Harbour Energy Proposed Protective Provisions

Shown as mark-up to the Harbour Energy Without Prejudice Protective Provisions as Submitted by the Applicant at DL5

Doc No	FLO-MOR-GIS-MAP012-Protective Provisions-Rev001	Rev	02
Alt Doc No	n/a		
Document Status	Approved for Use	Doc Date	11 March 2025
PINS Doc Ref	3.5	APFP Ref	n/a

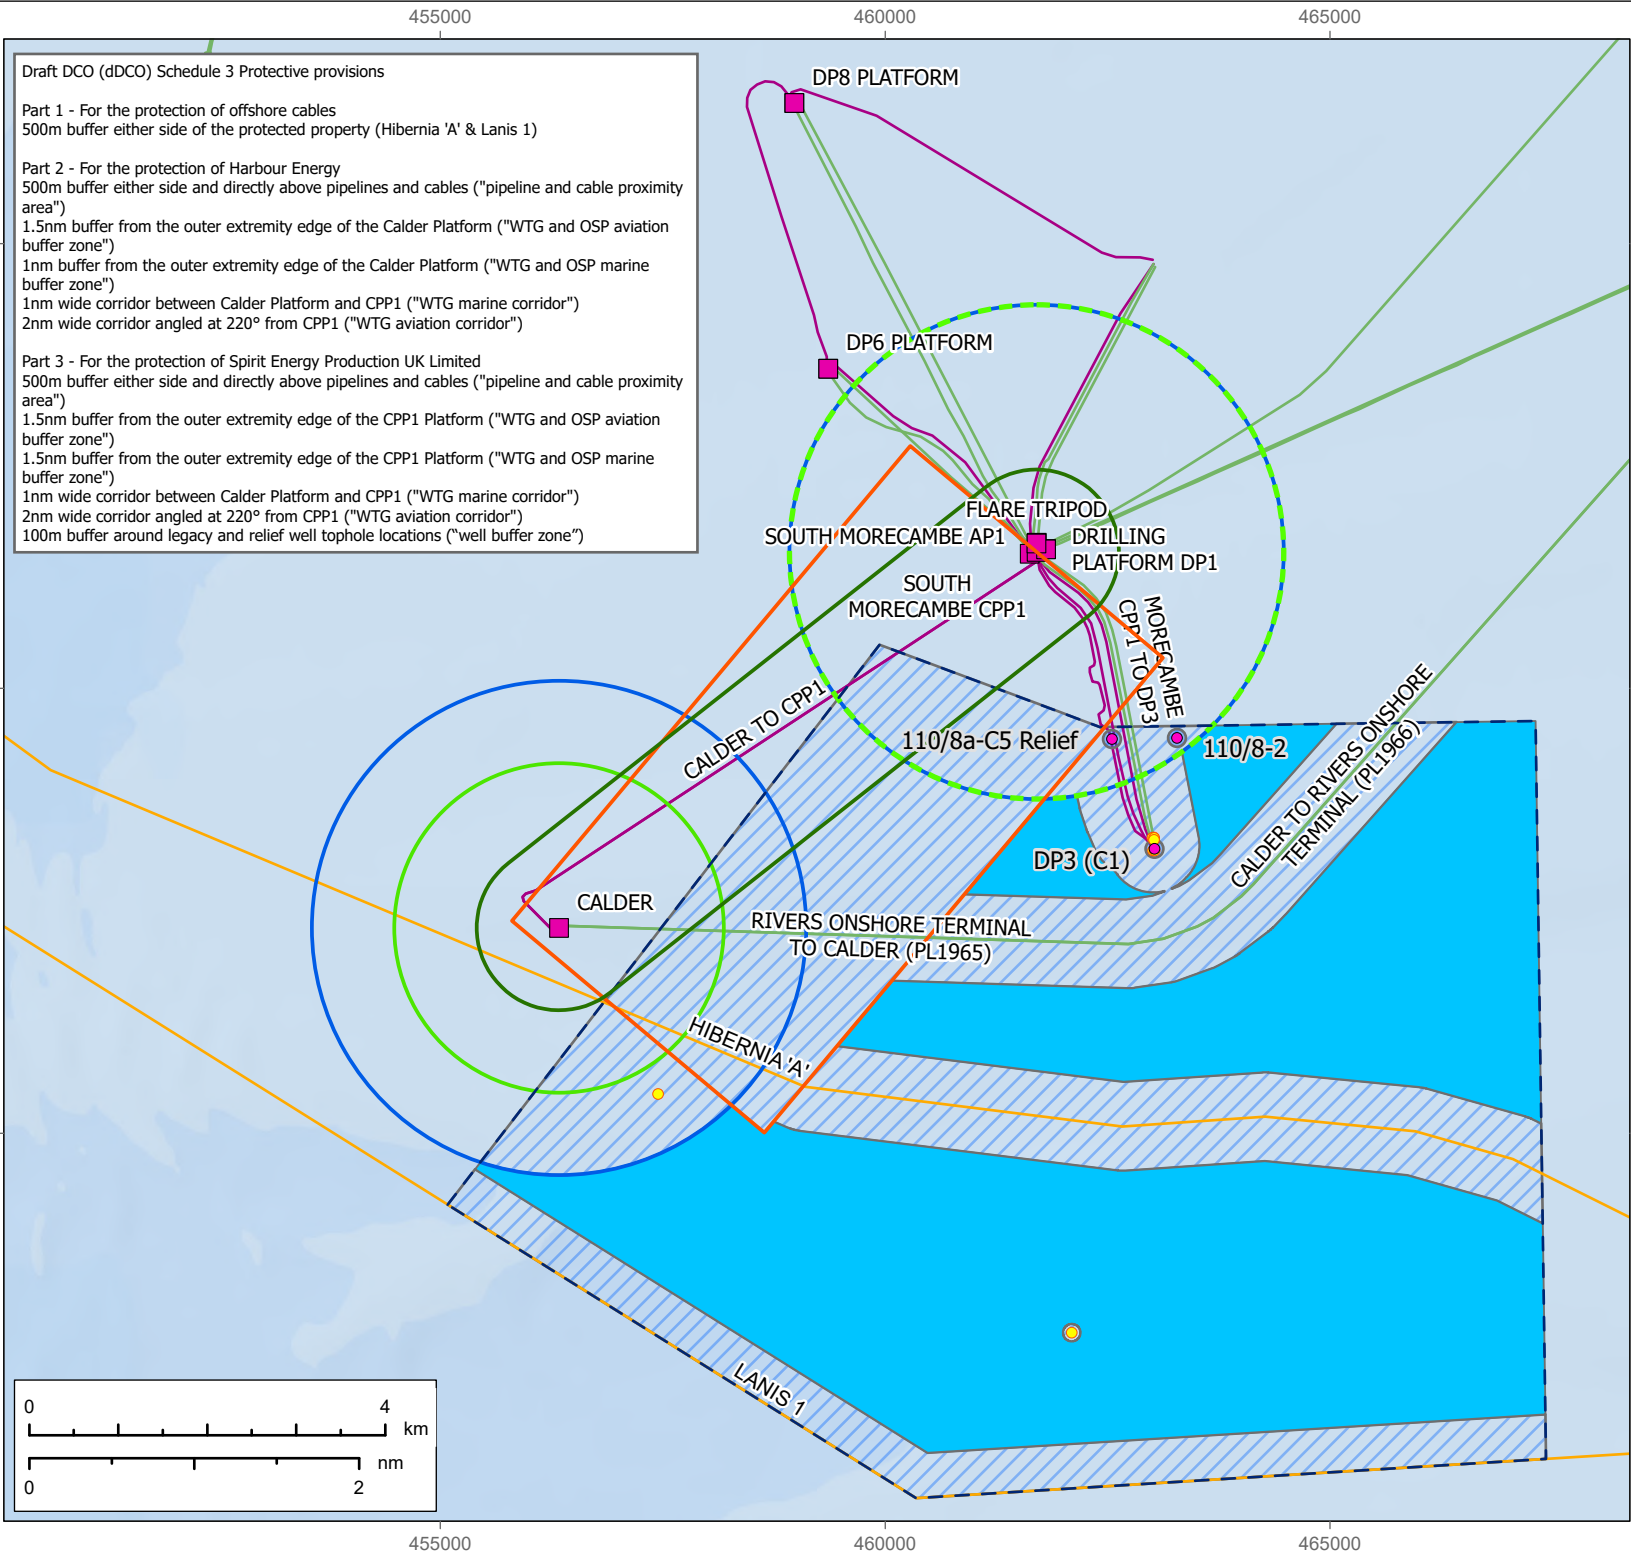
“pipeline and cable proximity area” means the area five hundred meters (500m) either side and directly above the pipeline and cable, shown coloured ~~pink~~ and annotated and shown as the pipeline and cable proximity area on the Spirit and Harbour Protective Provisions Plan;

“WTG and OSP aviation post-COP buffer zone” means a circular area of one point five nautical miles (4.51.9 nm) of clear airspace measured from the nearest outer extremity edge of the Calder Platform to any tip from any wind turbine generator located within the licence order limits and extending vertically from mean sea level, shown edged blue and annotated and shown as the WTG and OSP aviation post-COP buffer zone on the Spirit and Harbour Protective Provisions Plan;

“WTG and OSP marine buffer zone” means an area of one (i) a circular area of three point seven six nautical miles (4.3.76 nm) of clear airspace measured from the nearest outer extremity edge of the Calder Platform to any tip from any wind turbine generator located within the licence order limits and extending vertically from mean sea level; and

(ii) a circular area three point seven six nautical miles (3.76 nm) of clear airspace measured from the nearest outer extremity edge of CPP1 to any tip from any wind turbine generator located within the order limits;

each as shown edged in light green/blue and annotated and shown as the WTG and OSP marine aviation buffer zone on the Spirit and Harbour Protective Provisions Plan; and

“WTG aviation corridor and OSP marine buffer zone” means a two an area of one nautical mile (2.1 nm) wide corridor of clear airspace angled at 220 degrees from CPP1 measured from the outer extremity edge of the Calder Platform and extending vertically from mean sea level shown edged in orange/light green and annotated and shown as the WTG aviation corridor and OSP marine buffer zone on the Spirit and Harbour Protective Provisions Plan; and

“WTG marine corridor” means a one nautical mile (1 nm) wide corridor of clear sea space between the Calder Platform and CPP1 edged in dark green and annotated and shown as the WTG marine corridor on the Spirit and Harbour Protective Provisions Plan.
